SSD-9670 - WSU Innovation Hub

2-6 Hassall Street, Parramatta
Section 4.55(1A) Modification Report

Submitted to Department of Planning, Industry
and Environment

03 December 2019 | 218990

Sheet Name
BASEMENT

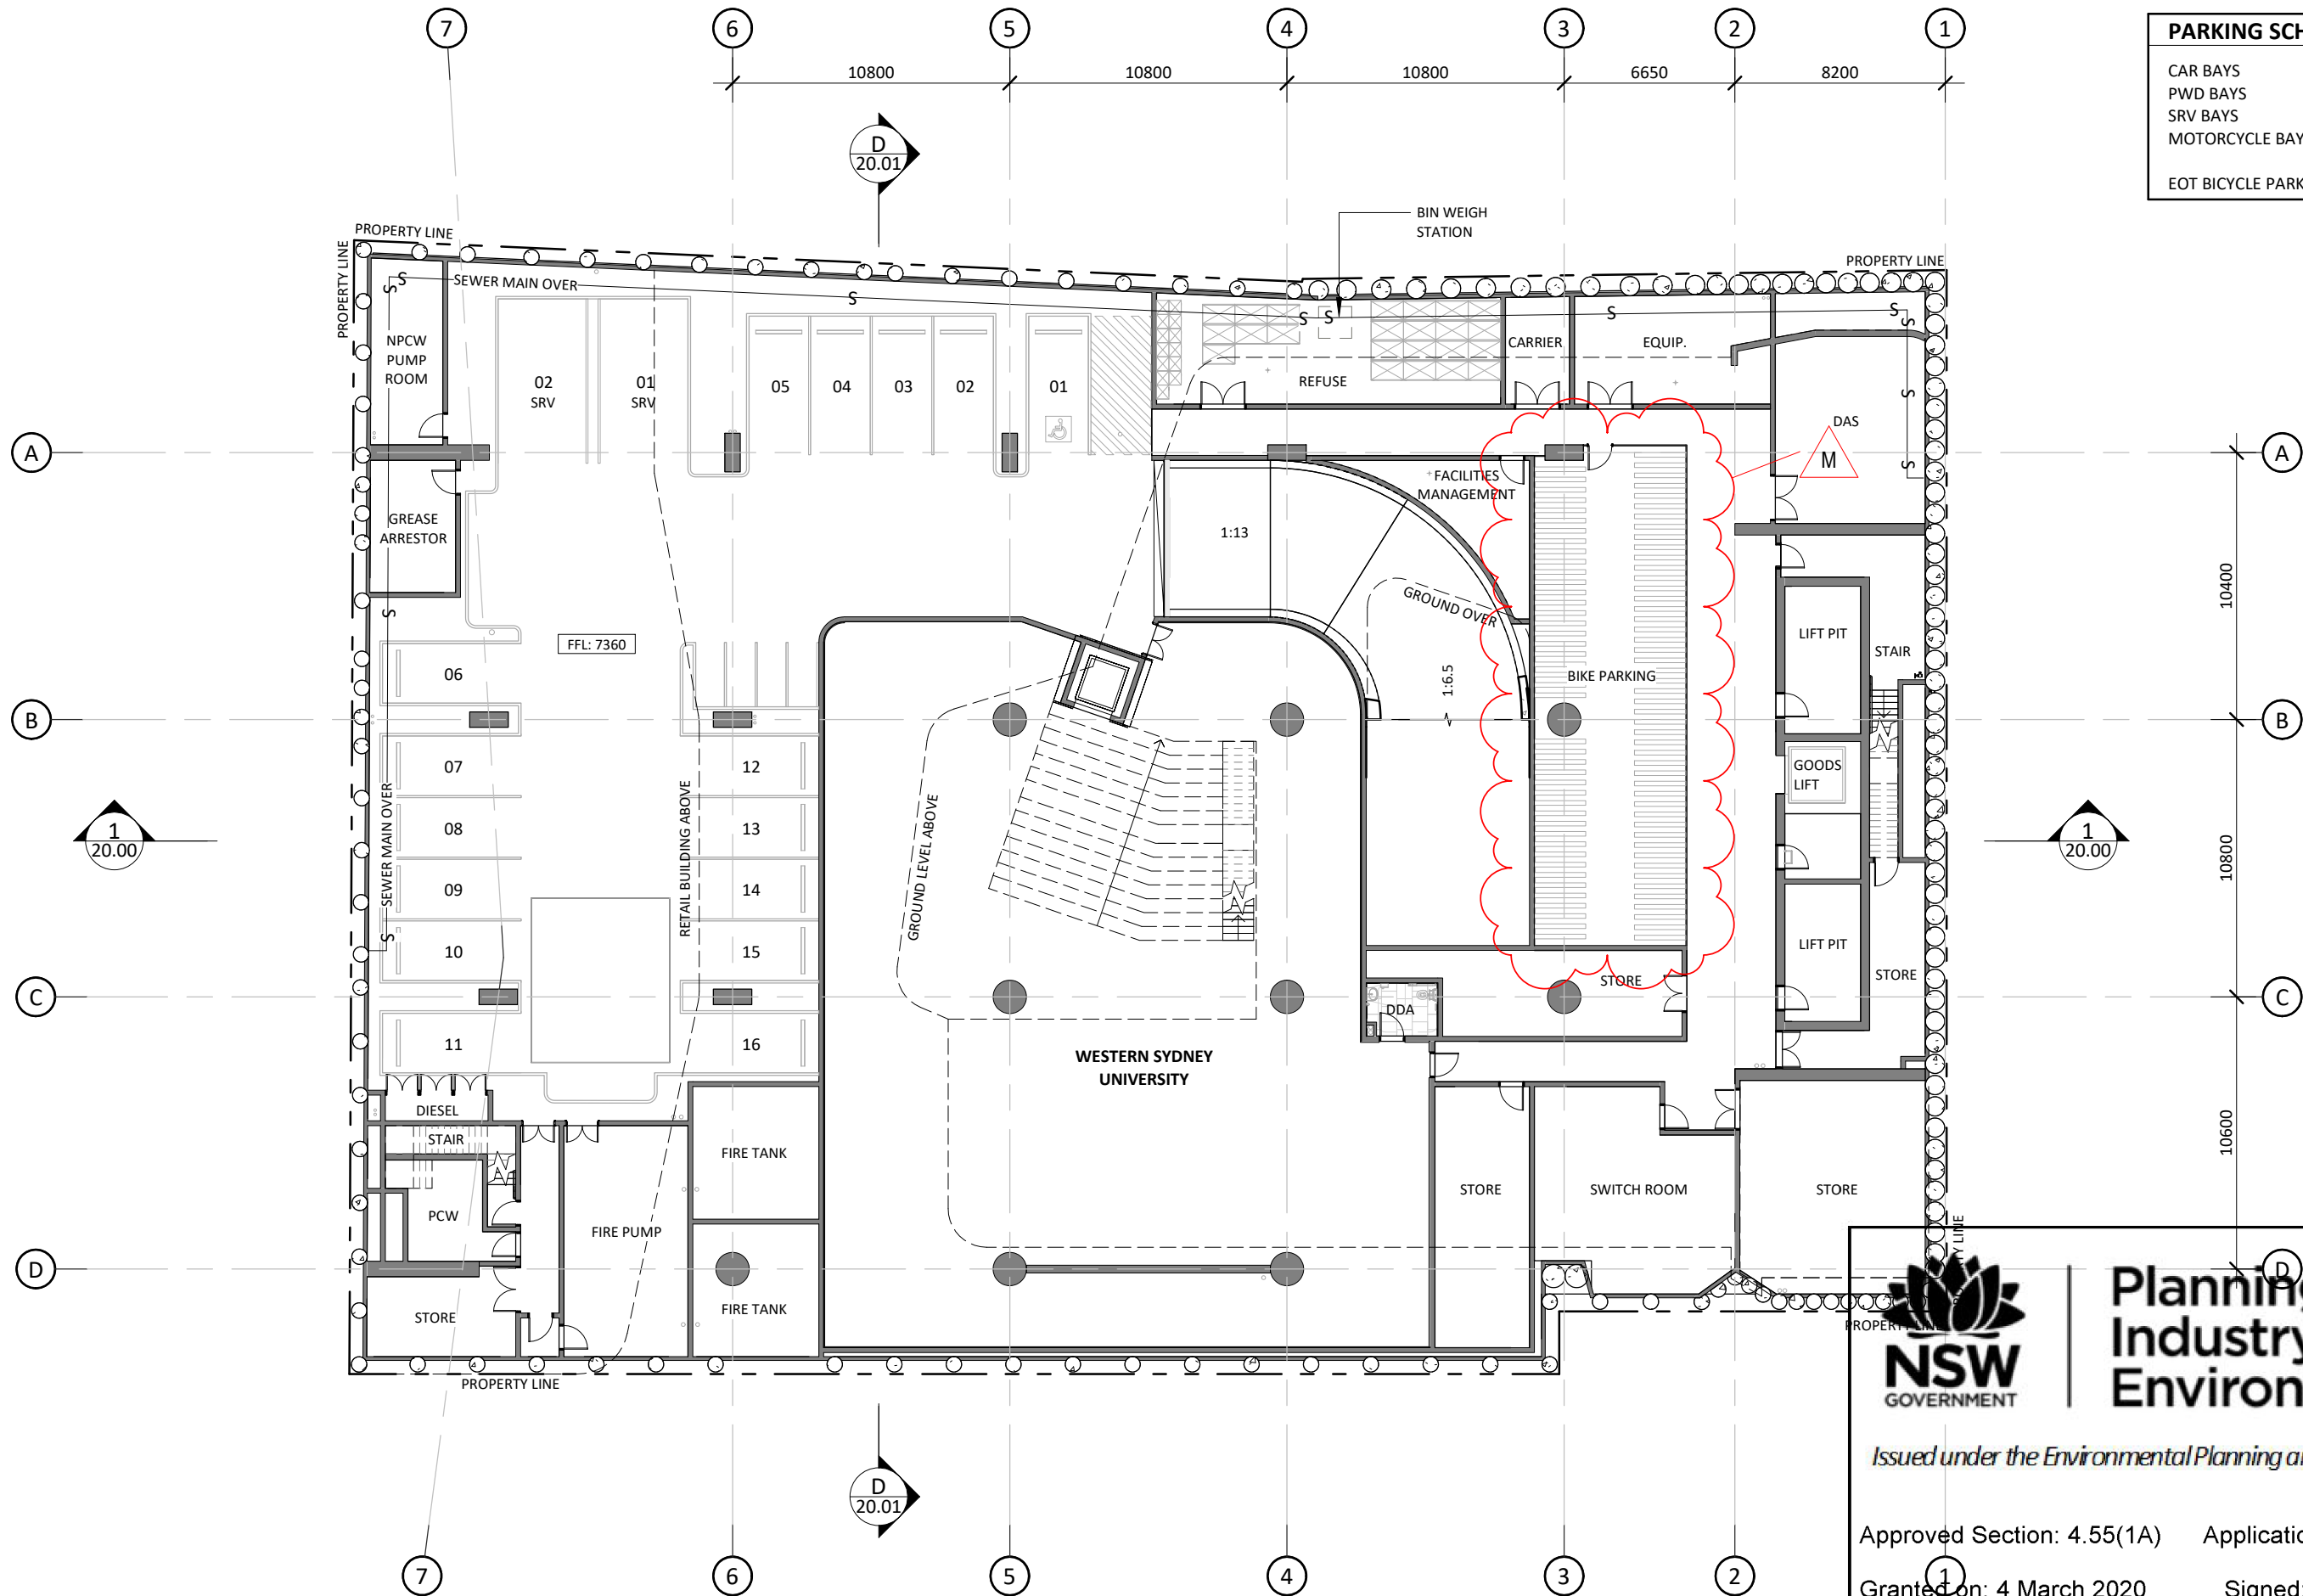
Architectural Plans prepared by Tzannes Blight Rayner			
Dwg No.	Rev	Name of Plan	Date
10.00	L <i>M</i>	Basement	09.08.2019 <i>27.11.2019</i>

Reason: The proposed modification to the basement plan reflects an update to the call out note to adjust the total number of bicycle parking spaces provided by the development. Refer to **Appendix A**. Further explanation is provided below in relation to Condition B30.

- a) the provision of a minimum ~~482~~ **177** bicycle parking spaces **(including a minimum of 163 bicycle parking spaces at the basement level and 14 bicycle spaces at ground level)**;
- b) the layout, design and security of bicycle facilities must comply with the minimum requirements of the latest version of AS 2890.3:2015 Parking facilities - Bicycle parking, and be located in easy to access, well-lit areas that incorporate passive surveillance;
- c) the provision of end-of-trip facilities for staff;
- d) appropriate pedestrian and cyclist advisory signs are to be provided; and
- e) all works/regulatory signposting associated with the proposed developments shall be at no cost to the relevant roads authority.

Reason: Based on a total net lettable area (NLA) of 27,694 sqm (as per the approved architectural drawings), the Green Star Building Council's requirements for publicly accessible bicycle parking is for a total of 177 spaces. The proposed modification clarifies the minimum spaces to be provided within the development's basement (163 spaces) and at the ground floor (14 spaces).

Figure 7: Suggested Treatments – Ground Level Plan

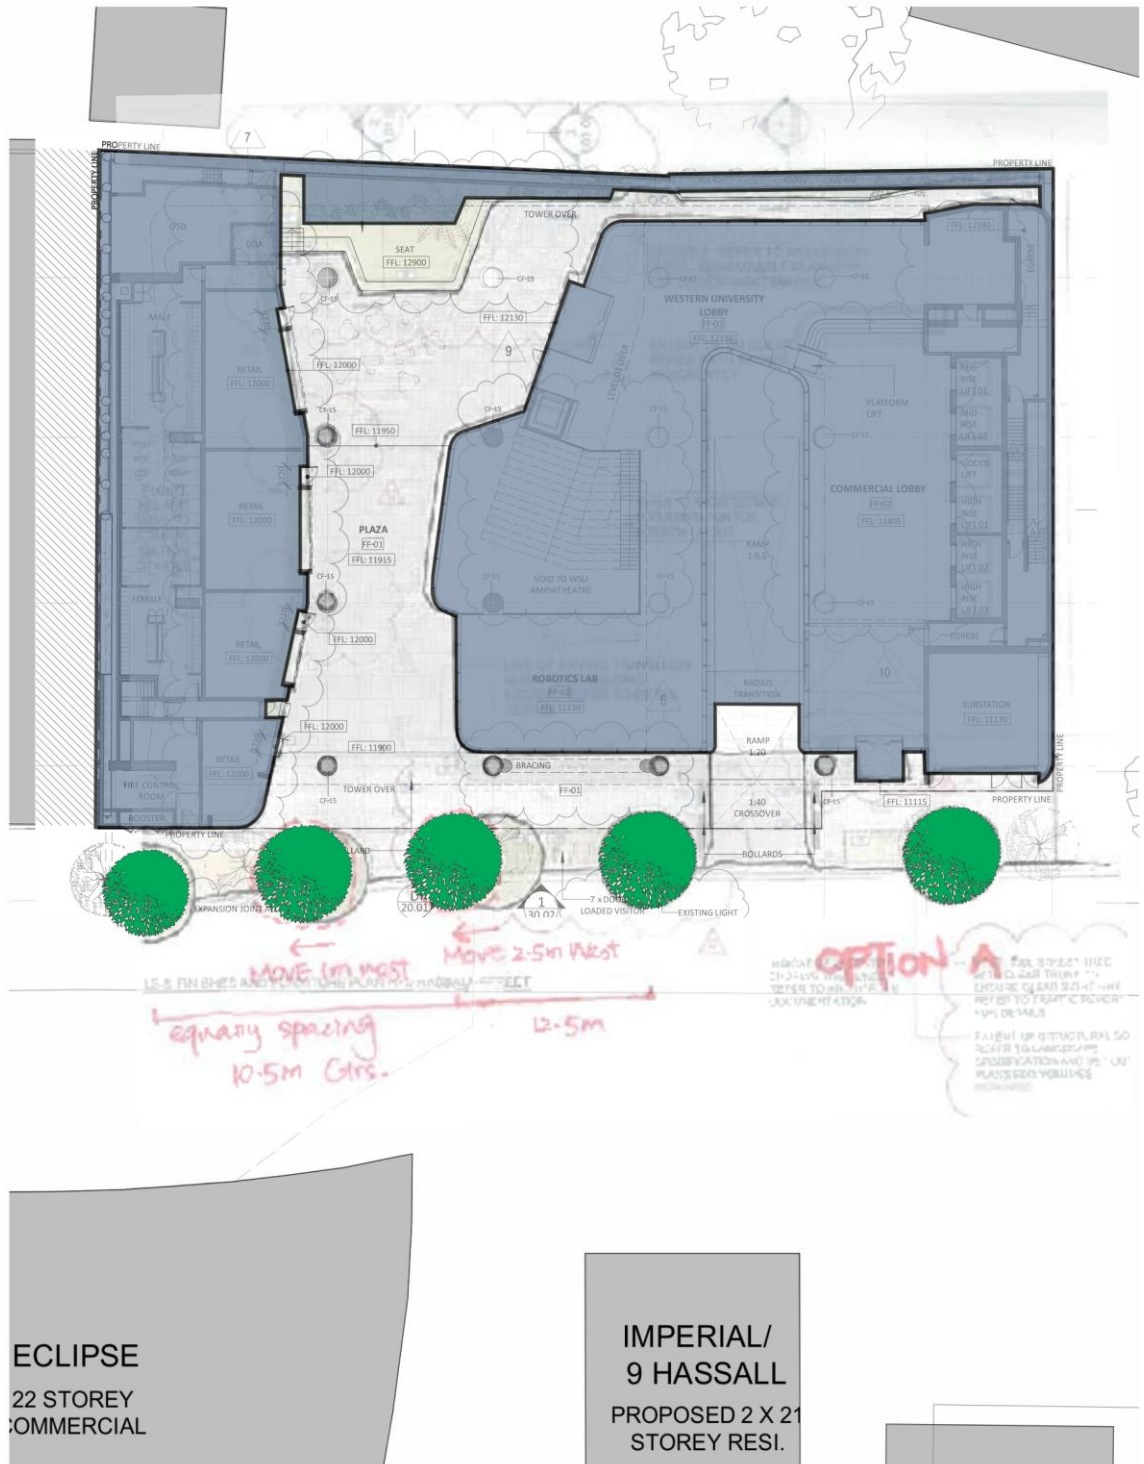
- Inclusion of the proposed trees at the southern entrance to the through site link, as referenced in Figure 7 of the wind report (and reproduced below). These trees should be densely foliating.

In relation to the recommendation above, the approved landscaping plan includes proposed street tree planting in locations generally consistent with the recommended locations. The final locations of the above trees will be coordinated with Council's Public Domain Section and resolved prior to commencement of public domain works.
